Recommendation Report for Planning Permission for Works or Extension to a Dwelling

REF NO: BE/6/19/HH

LOCATION: 72 Sunningdale Gardens
Bersted
PO22 9LF

PROPOSAL: Two storey side/rear extension

PROPOSED FIRST FLOOR PLAN

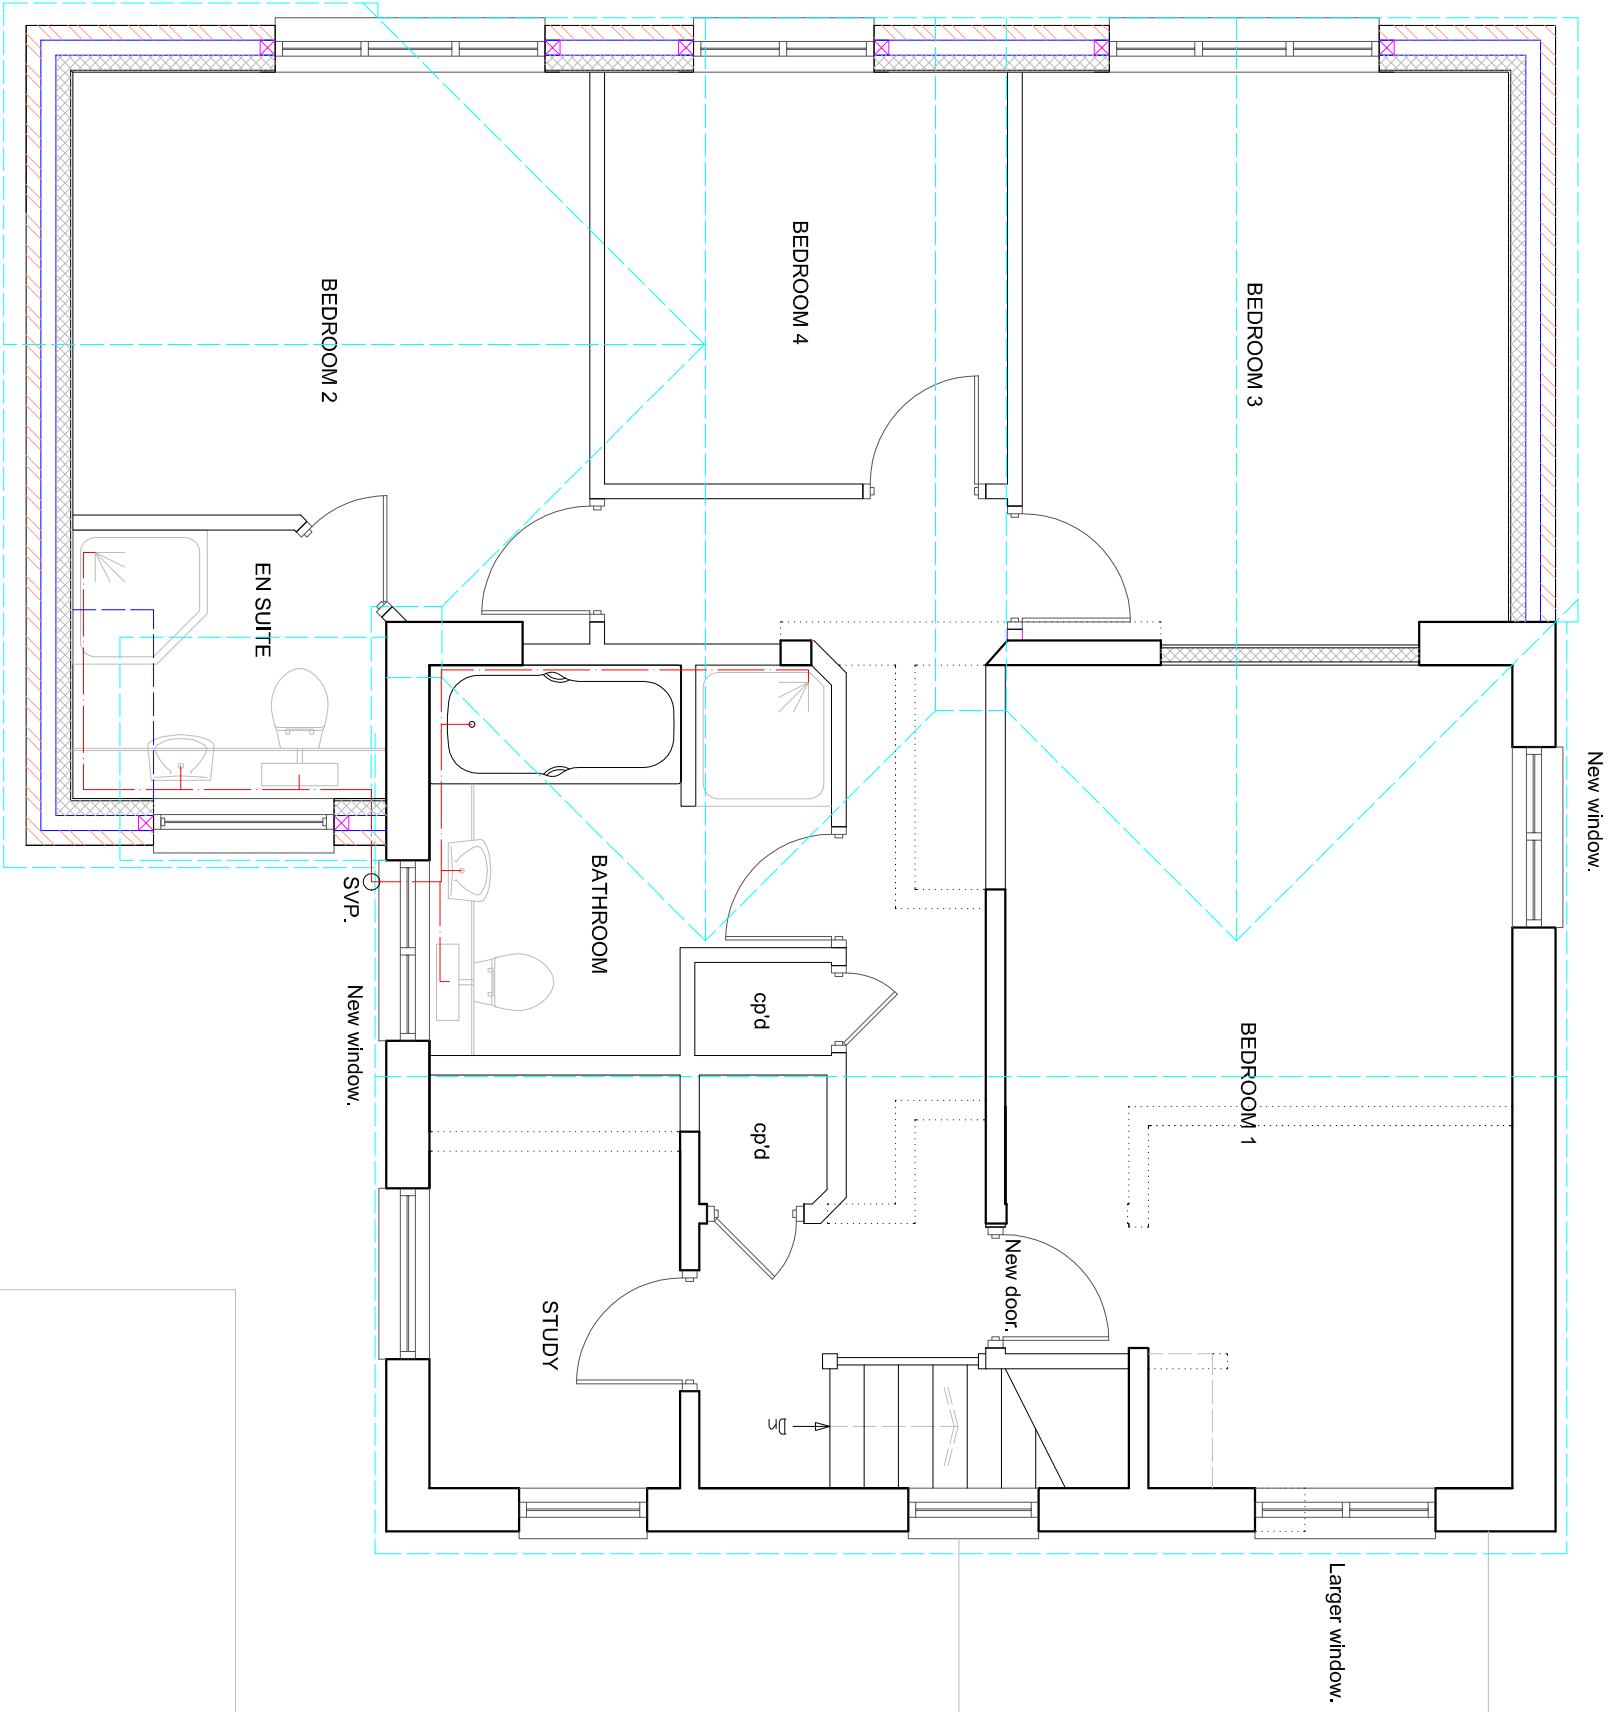
A first floor window will be installed to the western side elevation however it will be obscured and fixed shut below 1.7m as shown on plan to reduce any adverse impacts. 2 windows will also be installed to the side elevation facing the street scene, however as the extension and dwelling is set behind that of No.74 the first floor en-suite window shall also be conditioned to remain obscured and fixed shut below 1.7m to prevent adverse overlooking to the rear garden of No 74. 2 additional windows will also be installed to the first and ground floor eastern side elevation however due to their siting which is front of that of the neighbouring property they are not considered to give rise to any adverse views over No.70.

- 3 The first floor window to the western elevation and first floor en-suite window to the southern

elevation of the building shall at all times be glazed with obscured glass and only openable at a high level, at least 1.7m above finished floor level.

PROPOSED ELEVATIONS

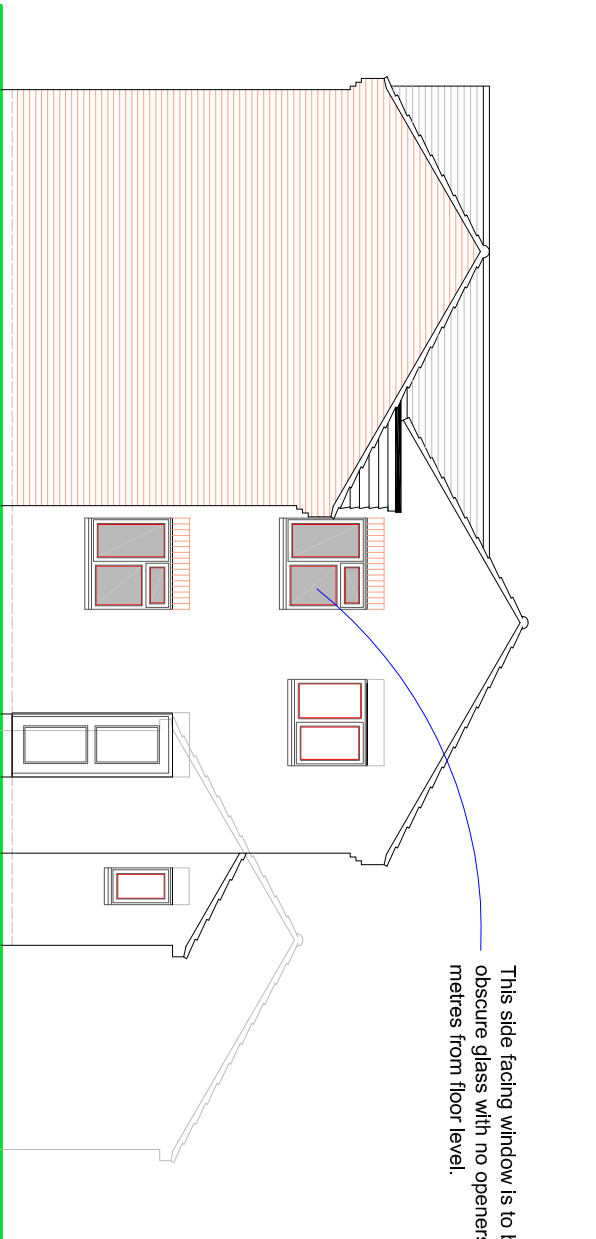
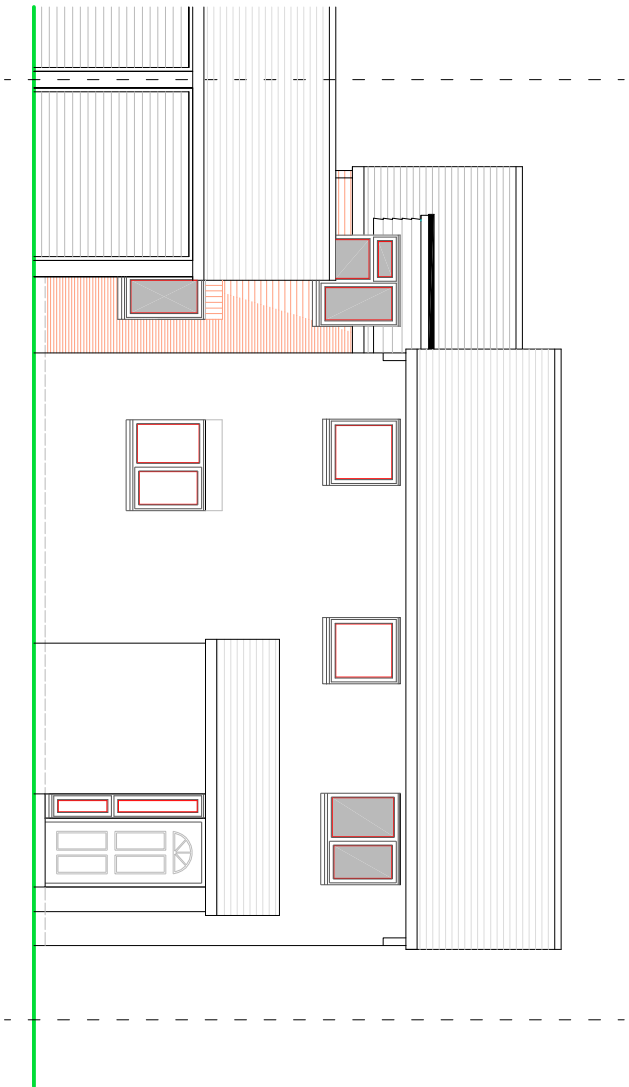
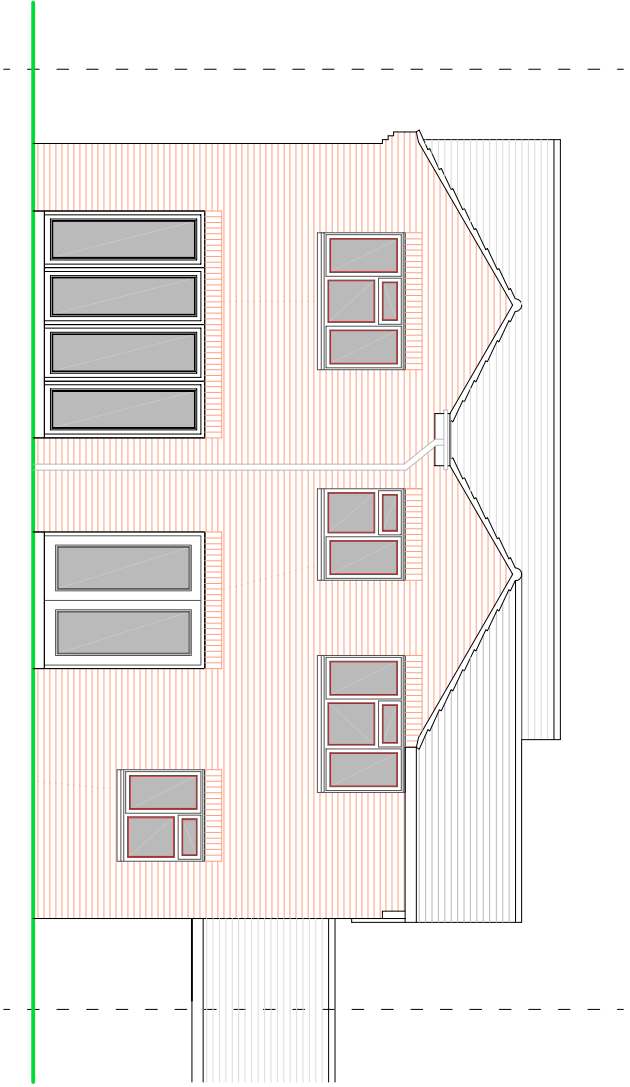
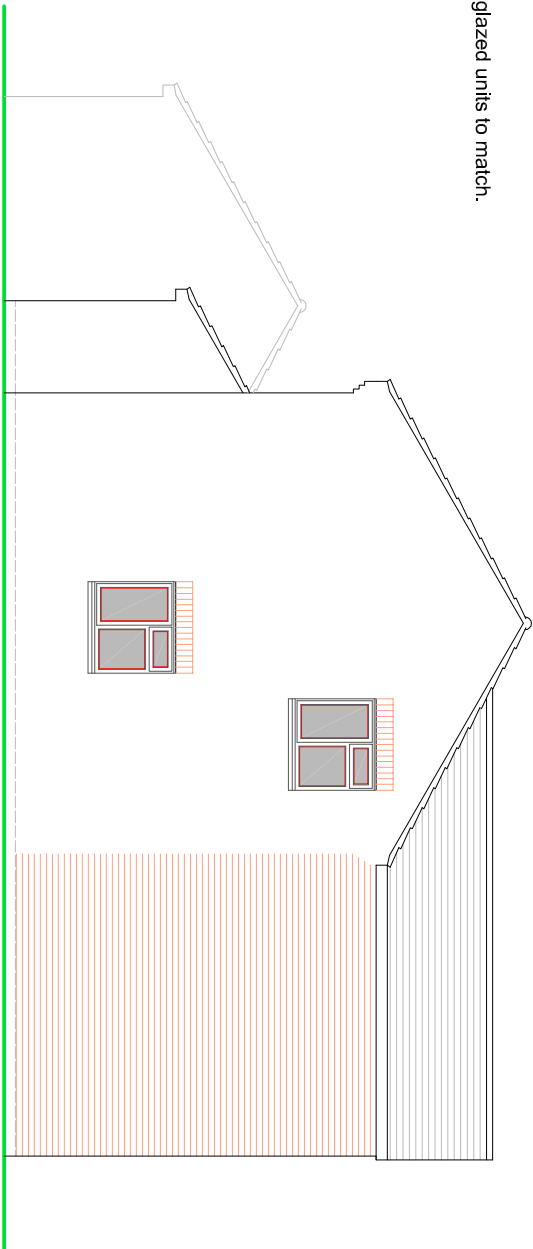
There are 3 windows proposed to the first floor rear elevation. Whilst there is only approximately 8m retained to the rear with first floor windows already in place, it is not considered views from these will increase significantly from that which is already possible in which a refusal would be justified.

PROPOSED GROUND FLOOR PLAN

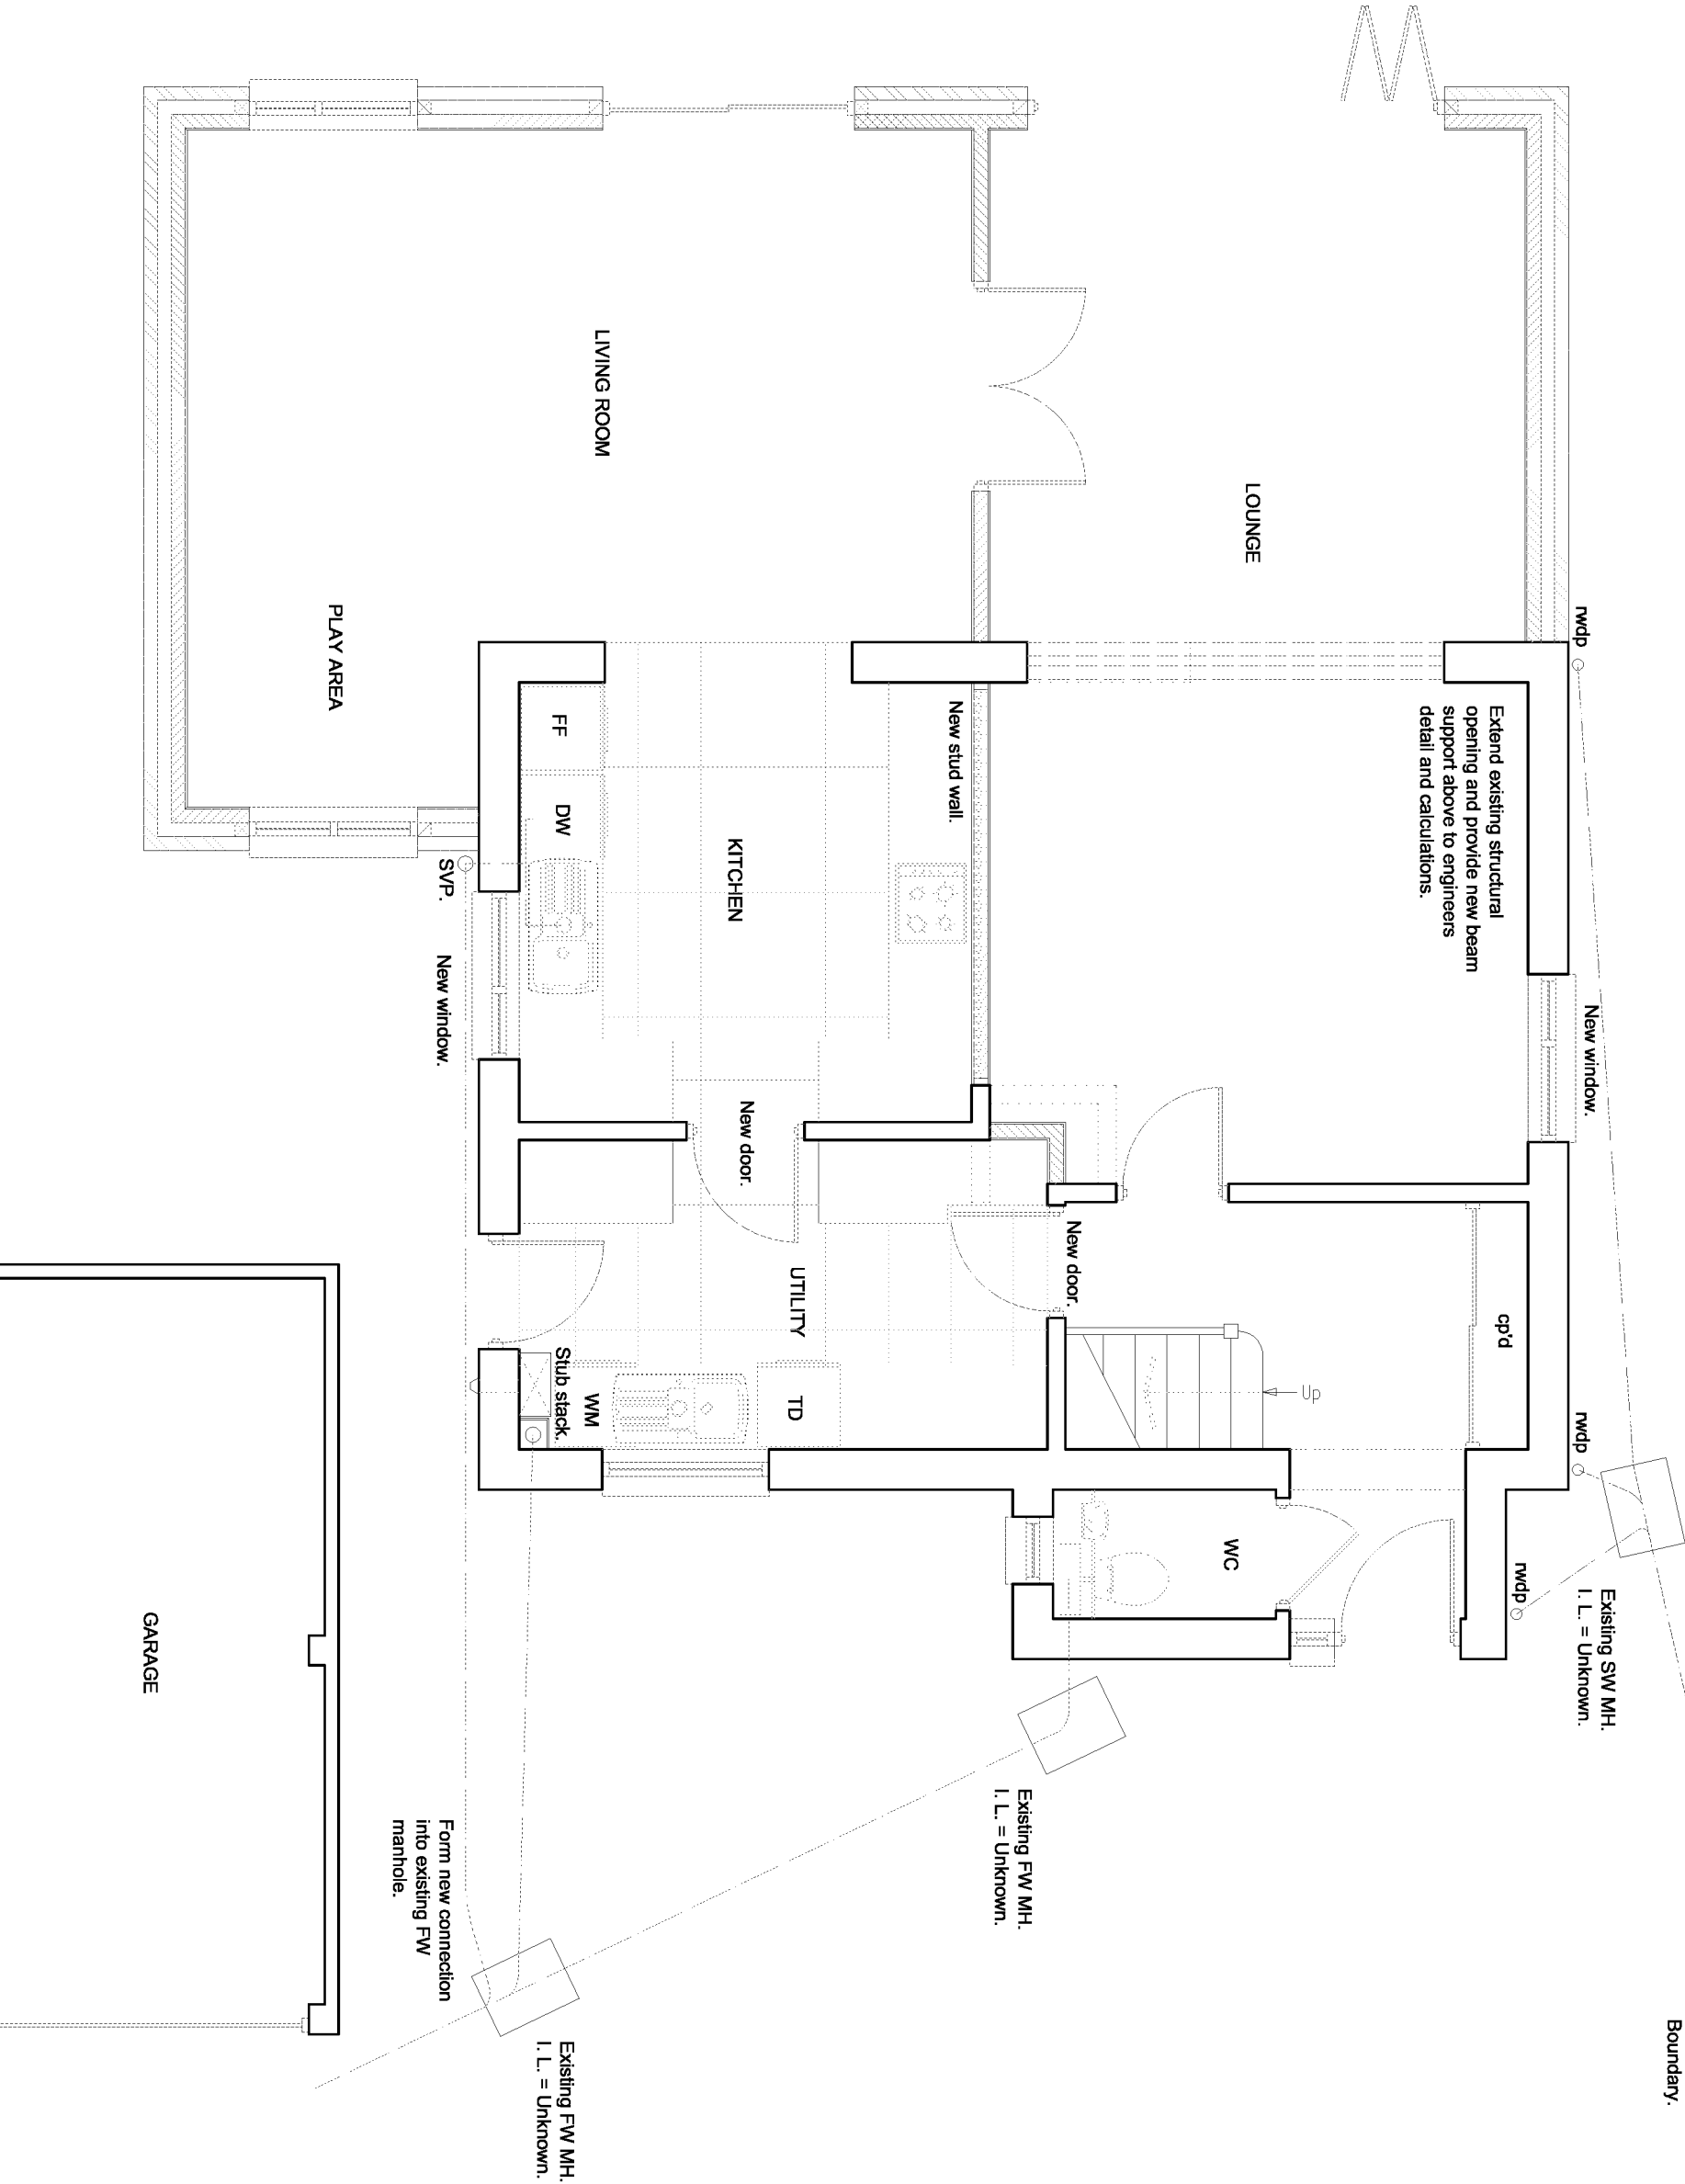
The proposal will extend 4m beyond the rear of the existing dwelling. This will run the full width of the rear and extend an additional 2.4m past the side elevation. This will then extend along the side for 1.5m.
